Planning Application No: 3/2026/0354

**Proposal: Proposed demolition of existing side extension and rear conservatory.
Construction of new two-storey side extension and single-storey rear extension.**

Location: 13 Brookside Old Langho BB6 8AP

Proposed Site Plan

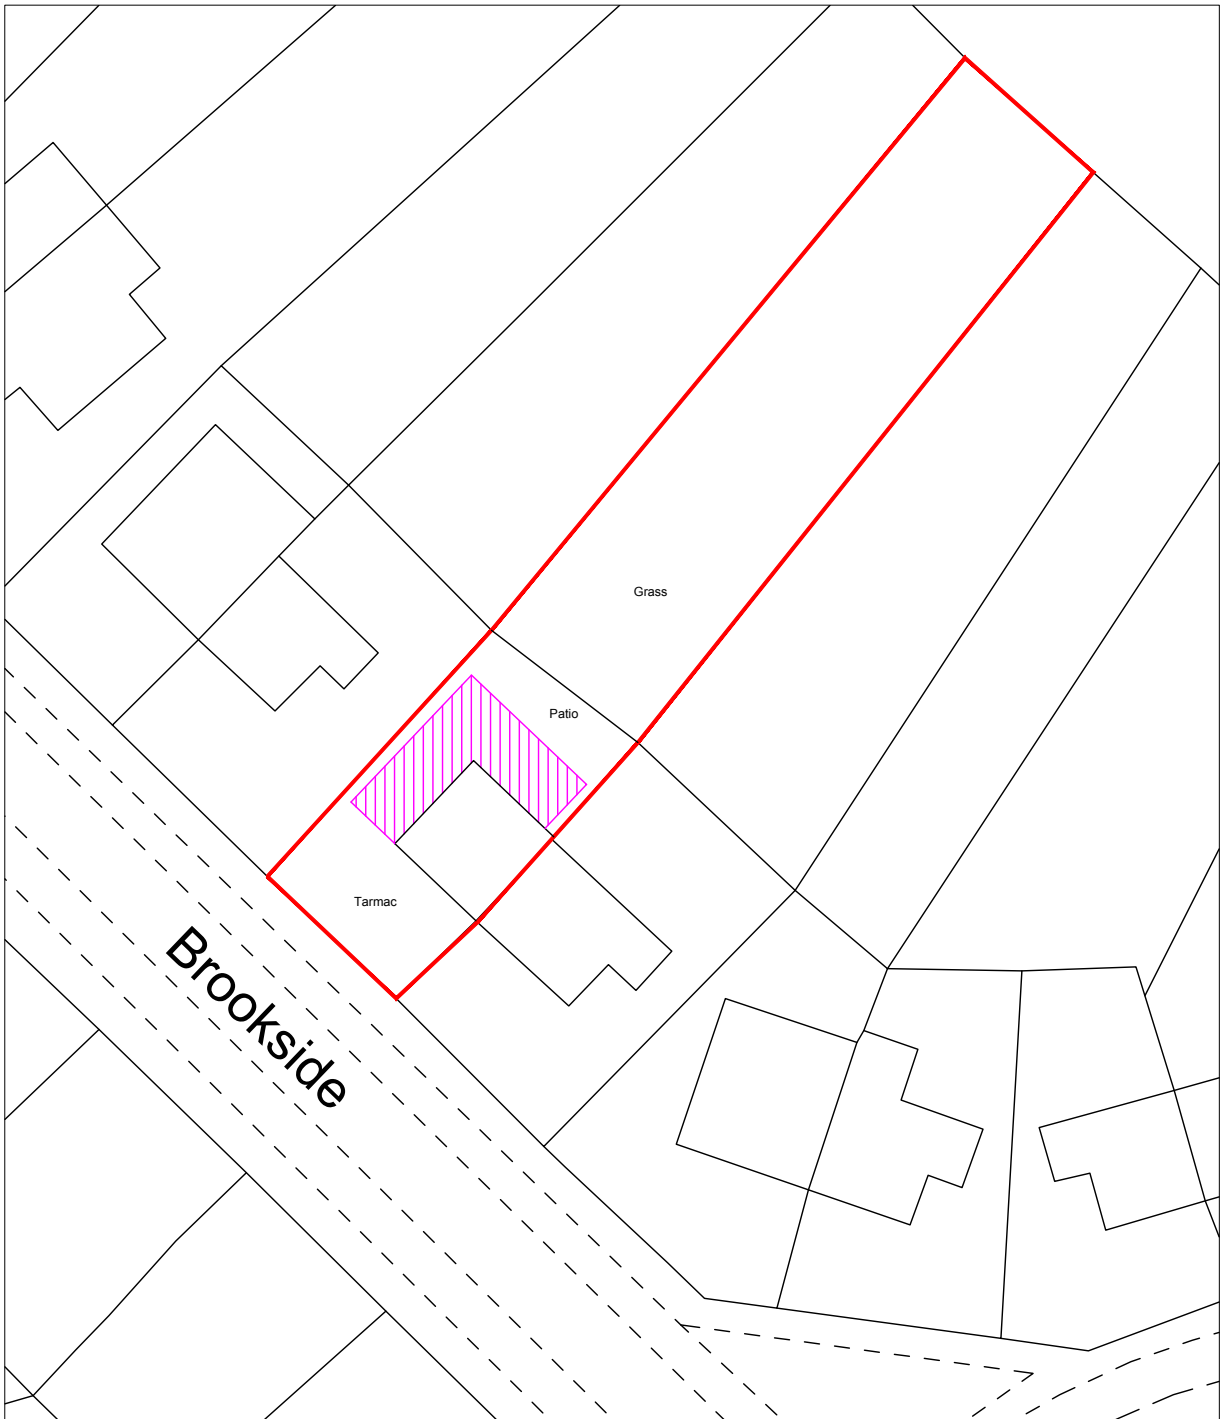
The front drive area is not reduced with the proposal. However, there is an increase in one bedroom from the existing 3 to a proposed 4 therefore, an increase in parking standard requirements. No parking plan has been submitted. There is no objection to the proposal subject to the 3 parking spaces required by parking standards are provided within the curtilage of the property.

Parking on a turning head is not acceptable for highway safety reasons.
